## **Locomotive Workshop Mod 7 –Expansion of Retail Uses into Innovation Plaza**

### **RTBU RMA Submission**

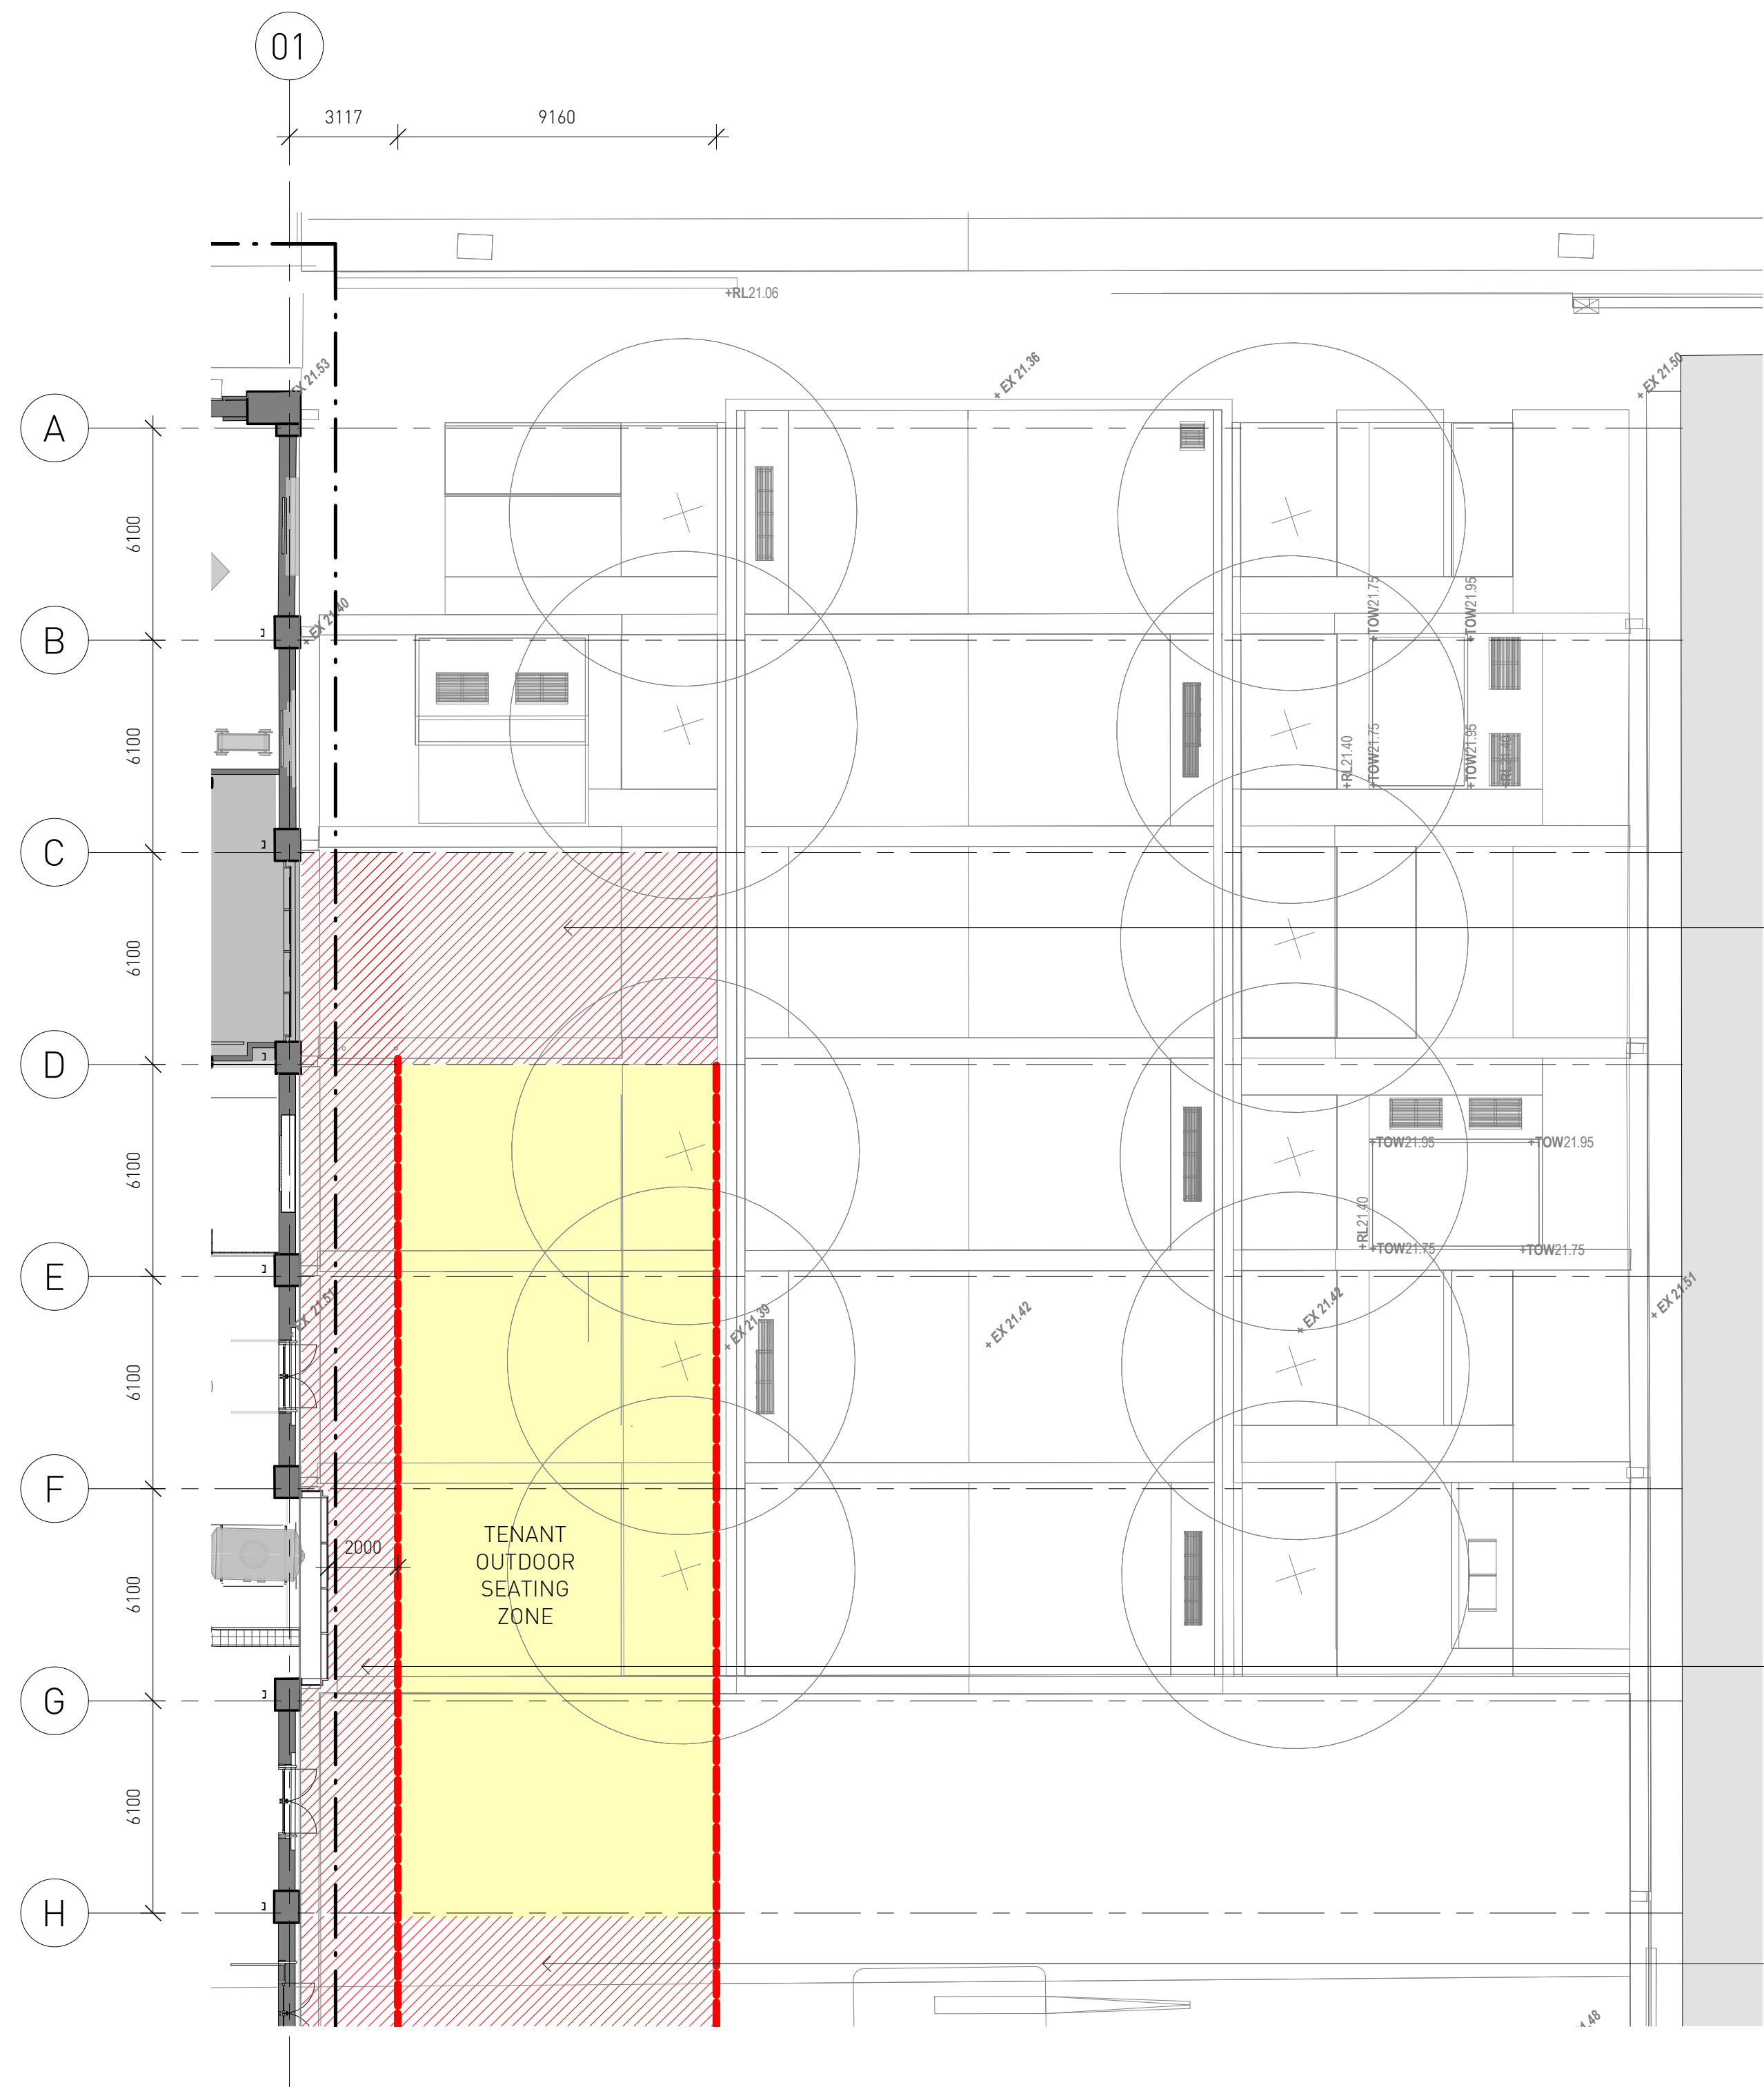
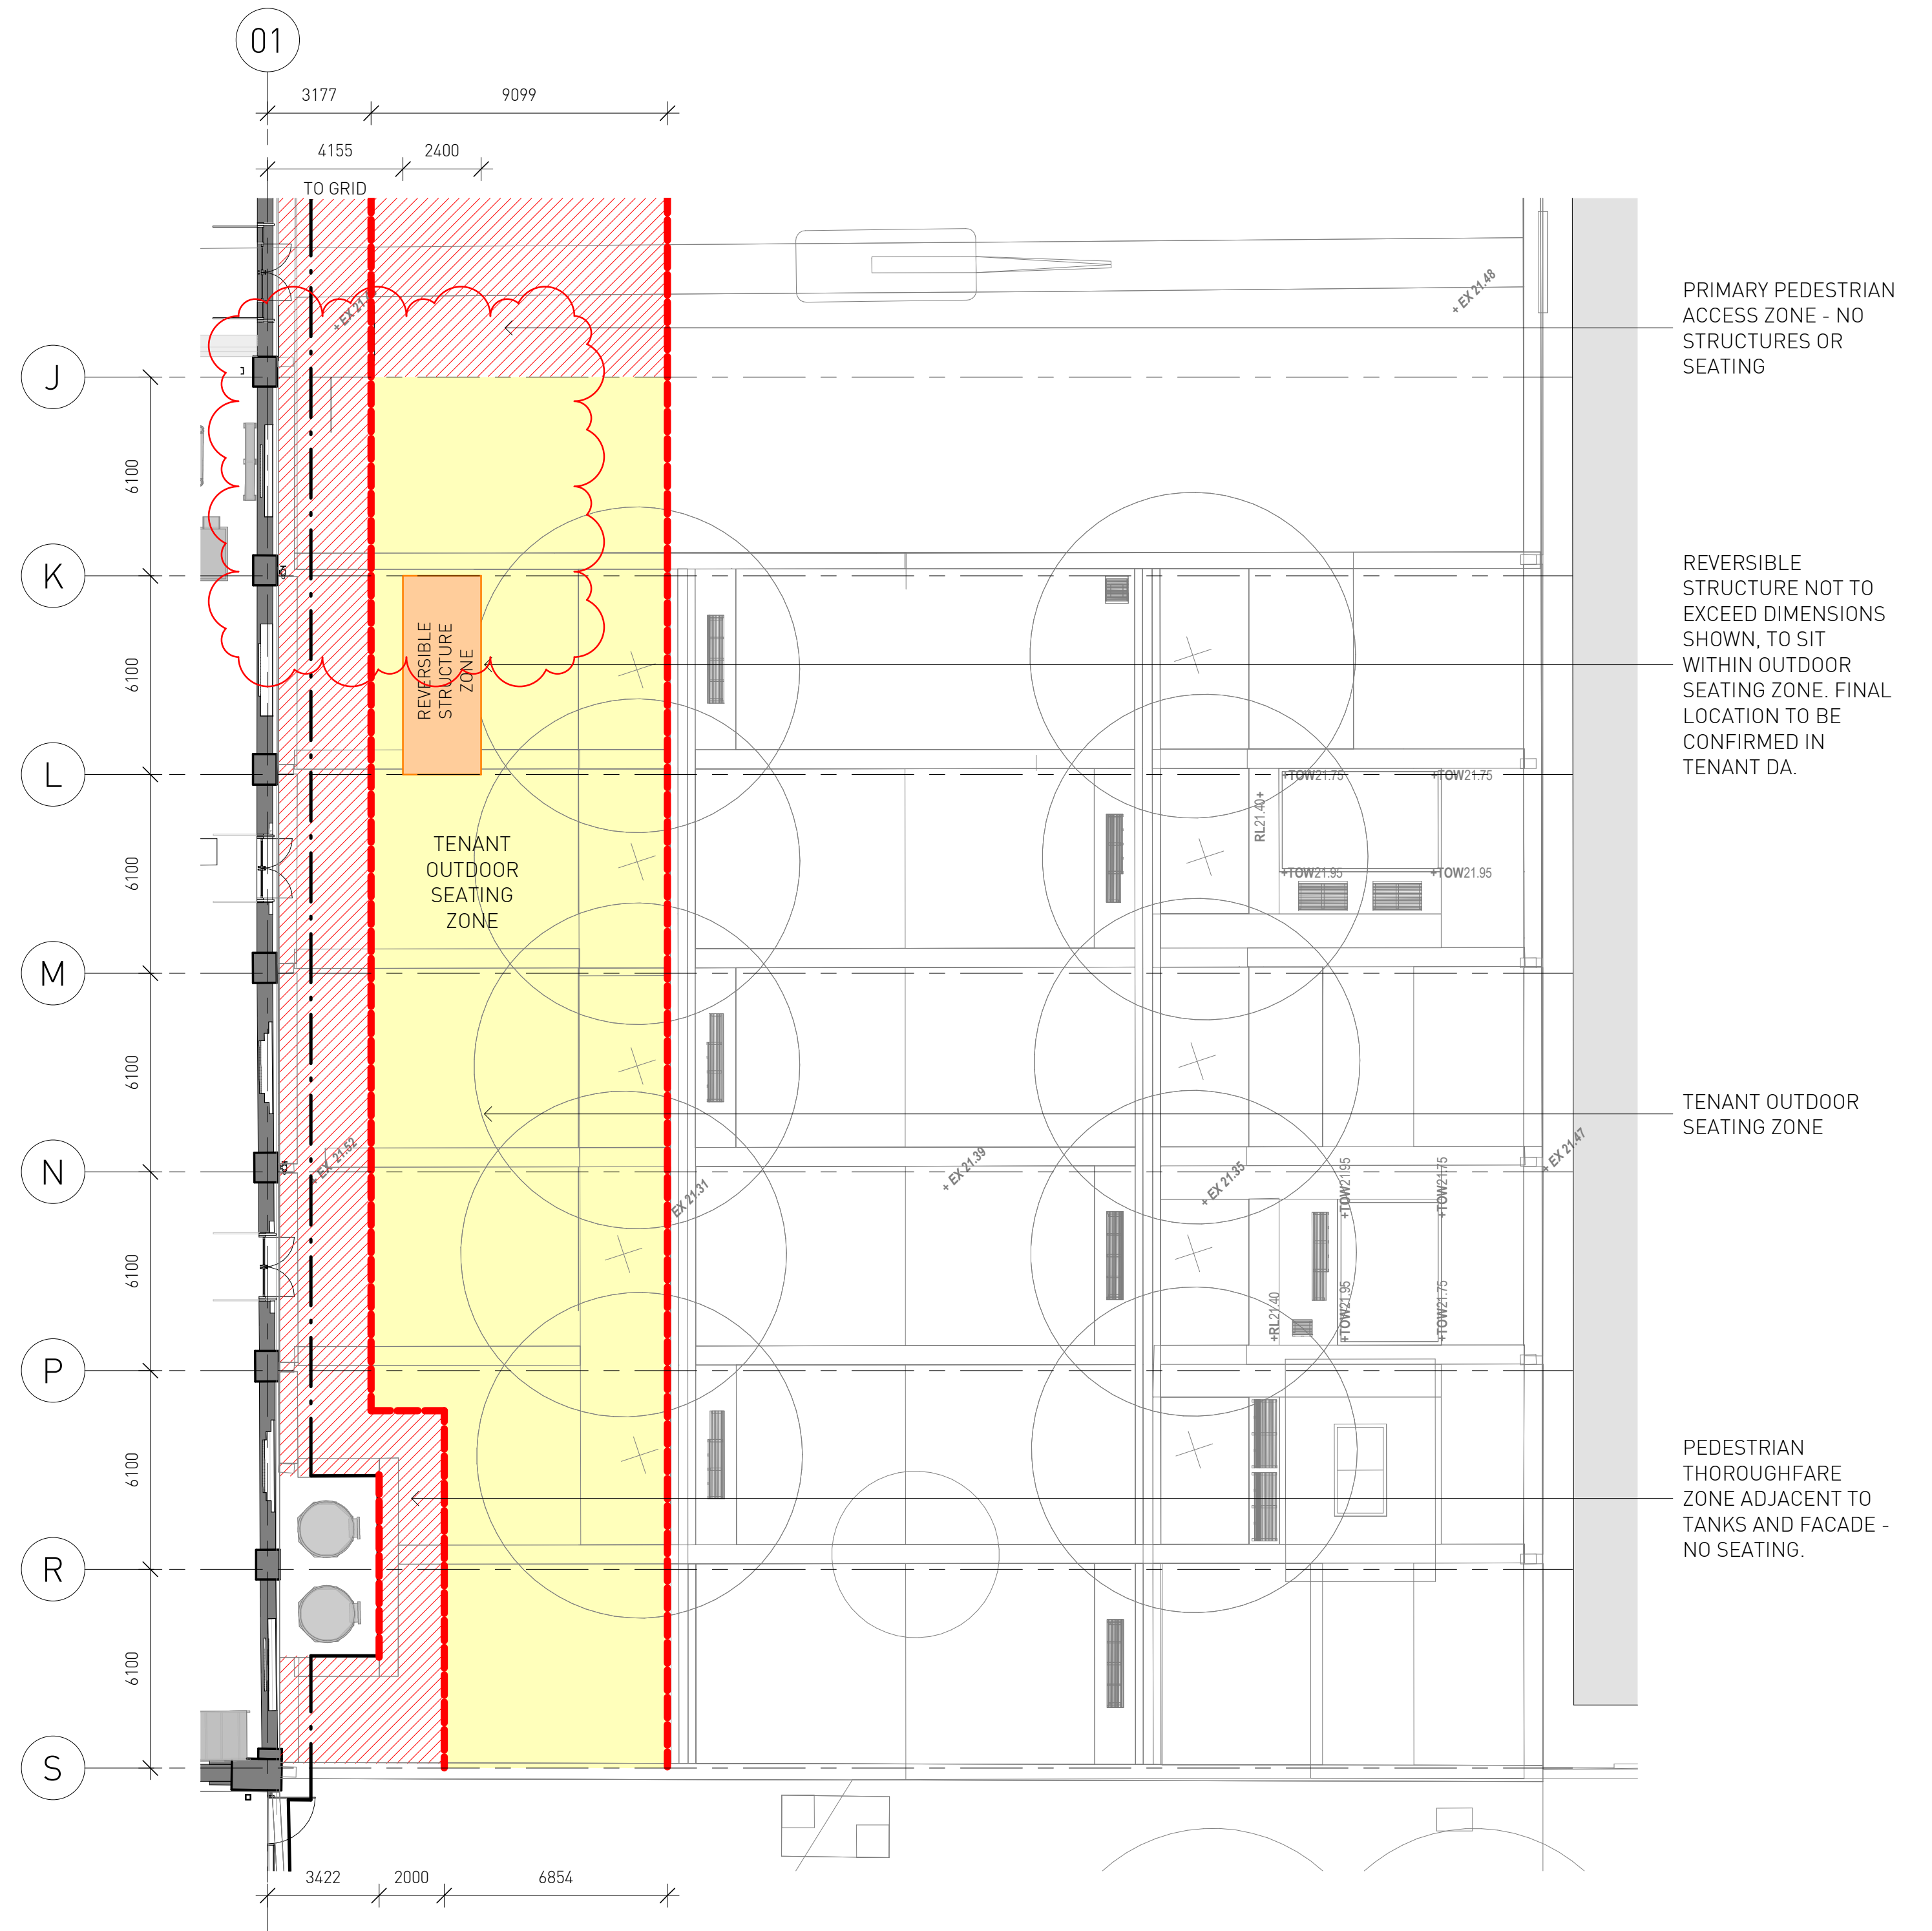
1. Innovation Plaza consists of 3675.8 square meters of public land and the application argues it will only excise 18% or 671.8 square metres of the footprint needed for the implementation of the commercial retail expansion application.

The quantitative assessment argues that the removal of 18% of the total of 3675.8m<sup>2</sup> is *"modest."* In order to put this into perspective the footprint of 671.8m<sup>2</sup> for the permanent commercial retail space is the size of 3.5 average sized Australian homes.

The RTBU RMA challenges the Applicants assertion that the proposed commercial retail footprint is minor in the context of the Plaza.

DRAWING NO.
LOCOMOTIVE-SSDA-09-REV3

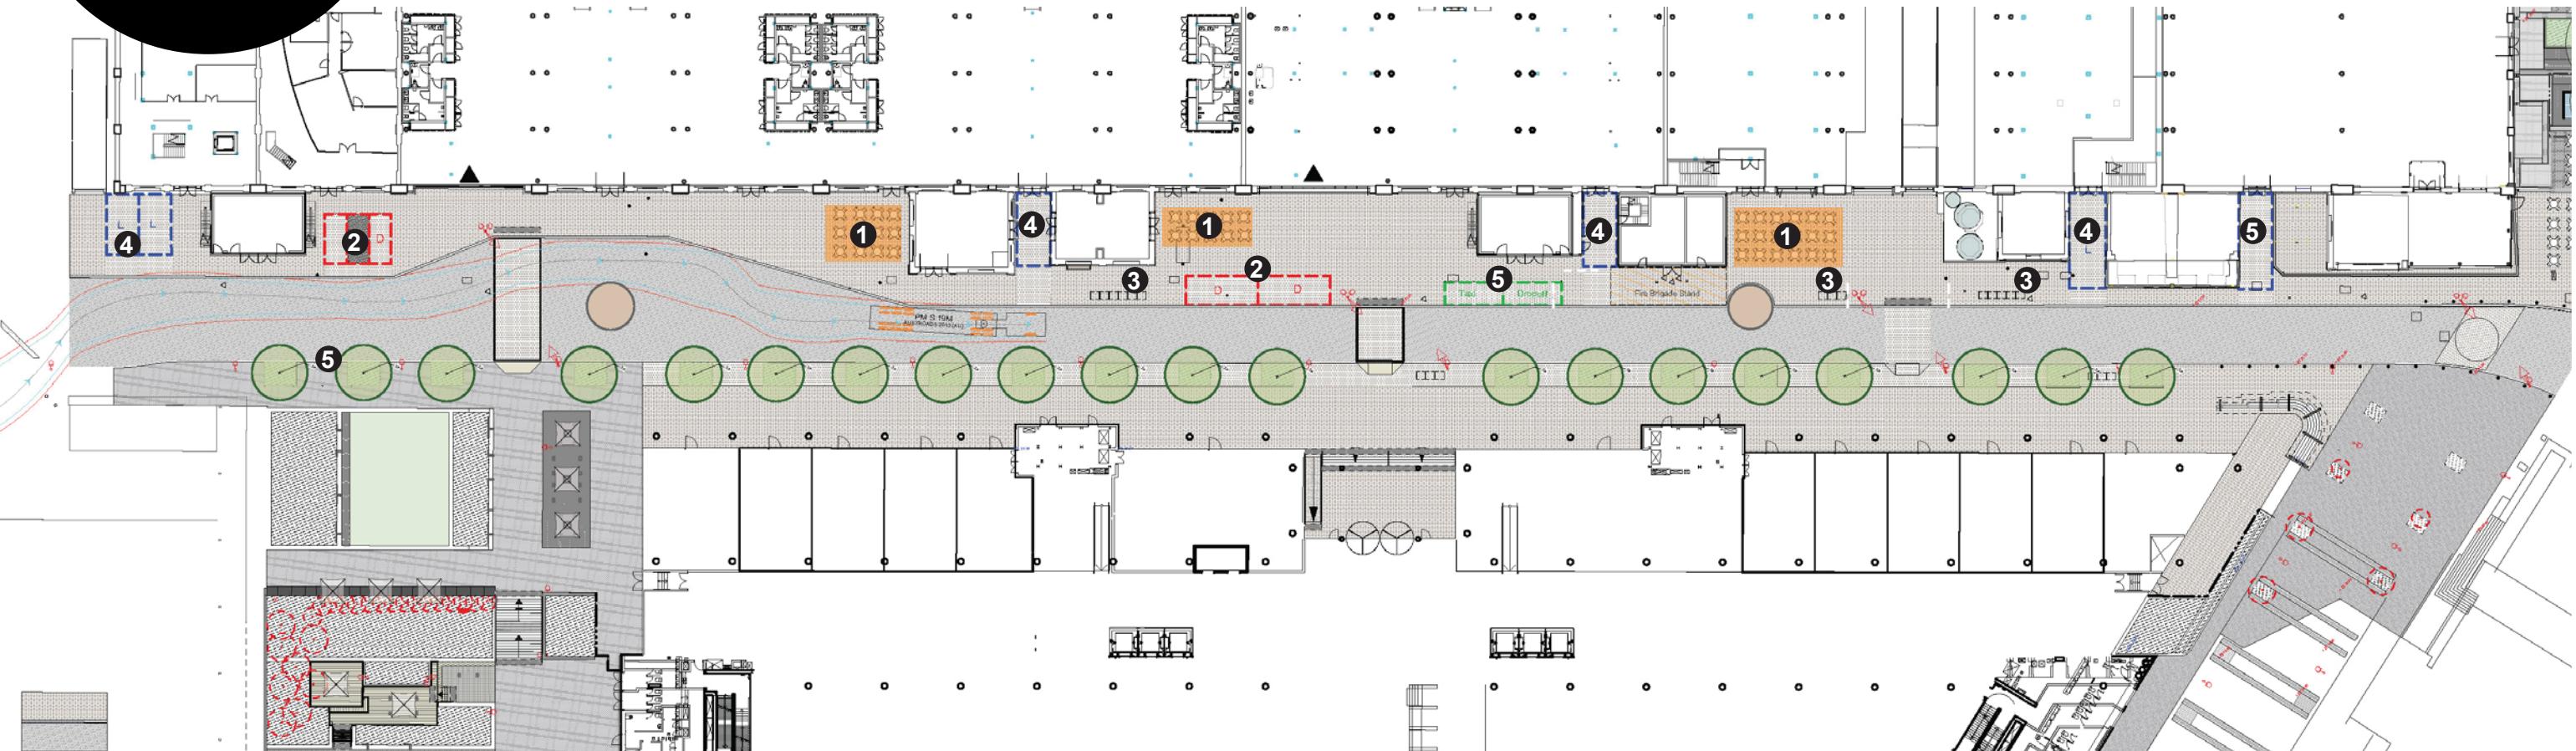
6. A number of other questions are raised by the Application. There is reference to a circulation path adjacent to the Locomotive Workshop. How large will it be and will it be closed to the public? A fleeting reference is made an option for events and two bar /keg structures. What are the implications of these on future uses of the Plaza for public recreation?

*An opportunity for patrons to comfortably sit and enjoy the visual amenity and industrial aesthetic.* A new principle of user pays is introduced. No mention is made of the impact on the public's amenity and industrial aesthetic appreciation and how it is impacted by the western side of the Plaza being commercialised with perhaps hundreds of patrons attended by new structures up to 4.8m in height, awnings and bar/keg facilities. Lines of sight will be severely disrupted.
